# MORGAN AND MORECAMBE OFFSHORE WIND FARMS: TRANSMISSION ASSETS

Notification of Intention to Submit a Change Request Application

PINS Reference: EN020028  
Document reference: S\_MMCR\_1/F02

**Notification of the Applicants' intention to submit a request for changes to the Transmission Assets Application**

**Drawing Number:**  
BP-GBR-MORG-REG-0176

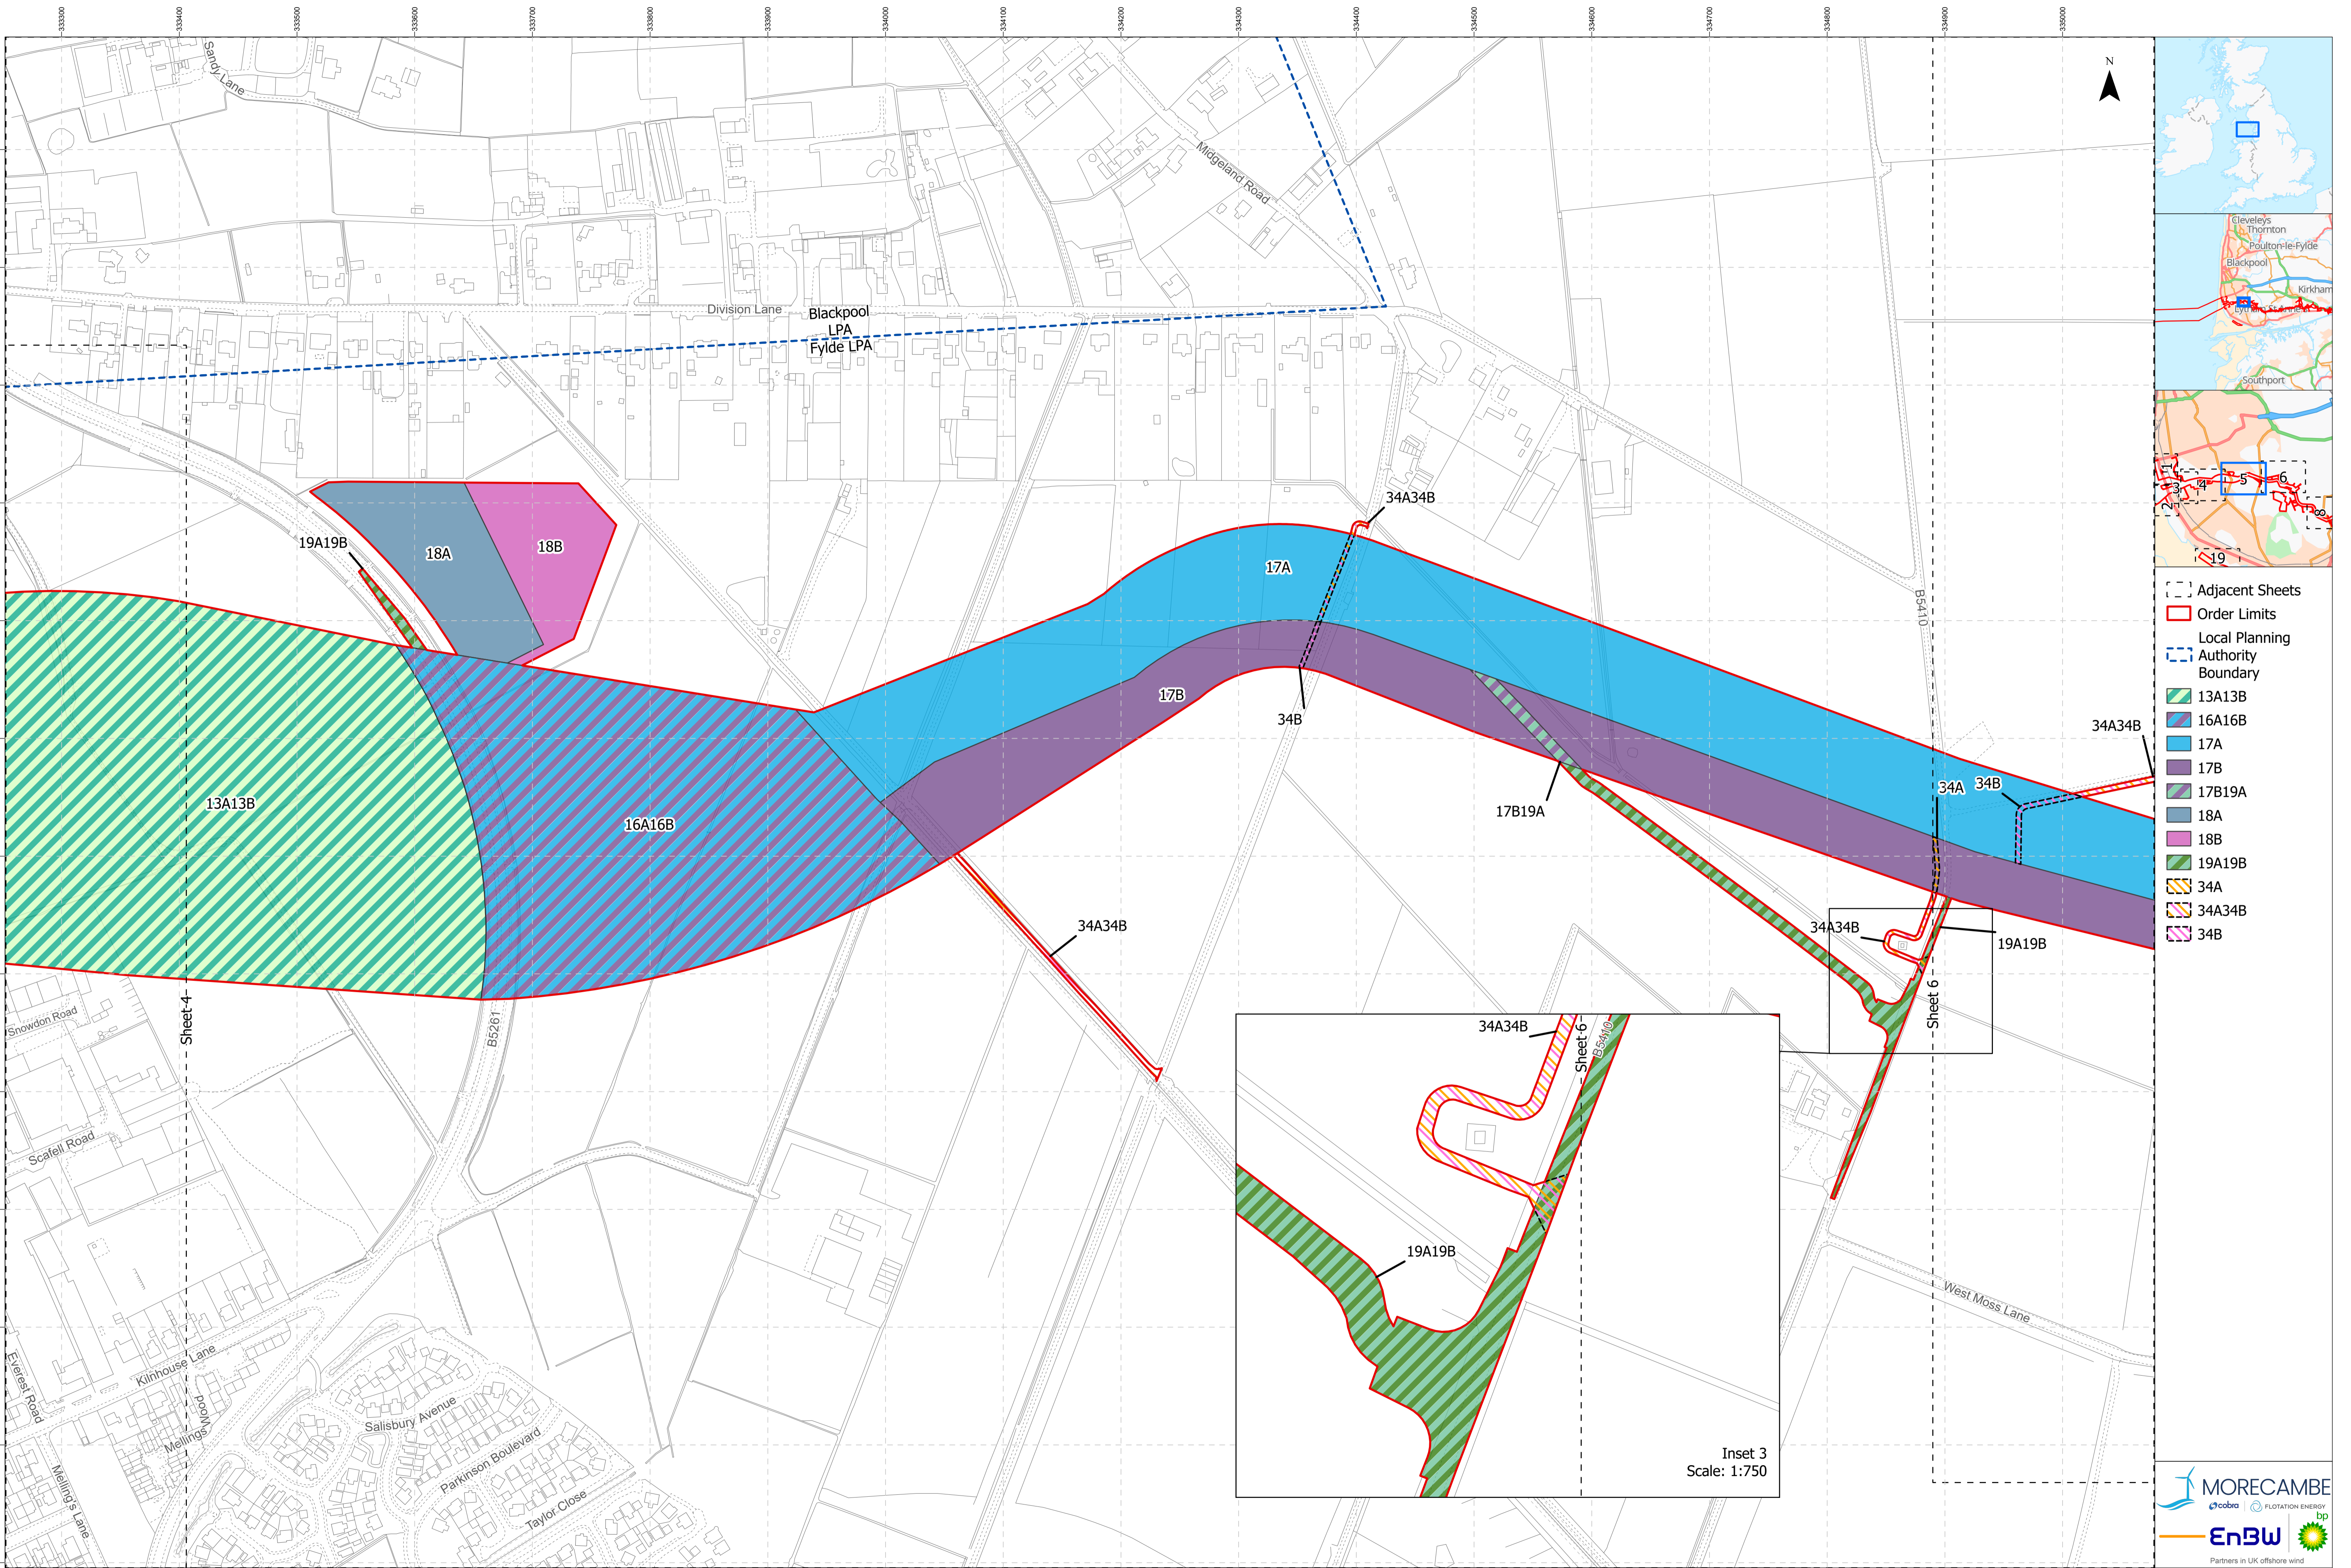
Change 4a involves amendment and reduction of the proposed Order Limits to remove any potential interaction with Runway 10/28 and land north of Runway 10/28 within Blackpool Airport operational land; currently included within Work Nos. 13A13B on Sheets 4 and 5 of the Works Plans – Onshore and Intertidal – Part 1 of 2 (REP3-007). The Applicants have made a commitment through negotiations with Blackpool Airport that cables will not be installed beneath Runway 10/28 and that the runway and land to the north of the runway is considered a restricted area, which means that no installation activities will take place. Therefore, this will result in a reduction of the Order Limits within Blackpool Airport. This involves the reduction in one plot of land (plot 04-024).

Change 4b involves amendment and reduction of the proposed Order Limits to reduce interaction with Blackpool Road Recreation Ground and reduce the interaction with one of the St Anne's Football Club 11-a-side pitches; currently included within Work Nos. 15A15B, 53A53B and 54A54B on Sheets 4 and 5 of the Works Plans – Onshore and Intertidal – Part 1 of 2 (REP3-007). Following feedback received from Fylde Borough Council and St Annes FC, and due to the commitments made by the Applicants through negotiations with Blackpool Airport not to undertake construction activities in the restricted area (as explained under Change 4a above), the swept path of onshore export cables in the northern section of Blackpool Road Recreation Ground can be reduced. This involves the reduction in five plots of land (plots 04-015, 04-016, 04-017, 04-018 and 04-019). [As requested during Issue Specific Hearing 2 on 29 July 2025, the Applicants will provide a figure within the Change Request application which illustrates the change overlaid with the current layout of 11-a-side football pitches at the Blackpool Road Recreation Ground \(which the Applicants acknowledge may be subject to future reconfiguration depending on the needs of the users\).](#)
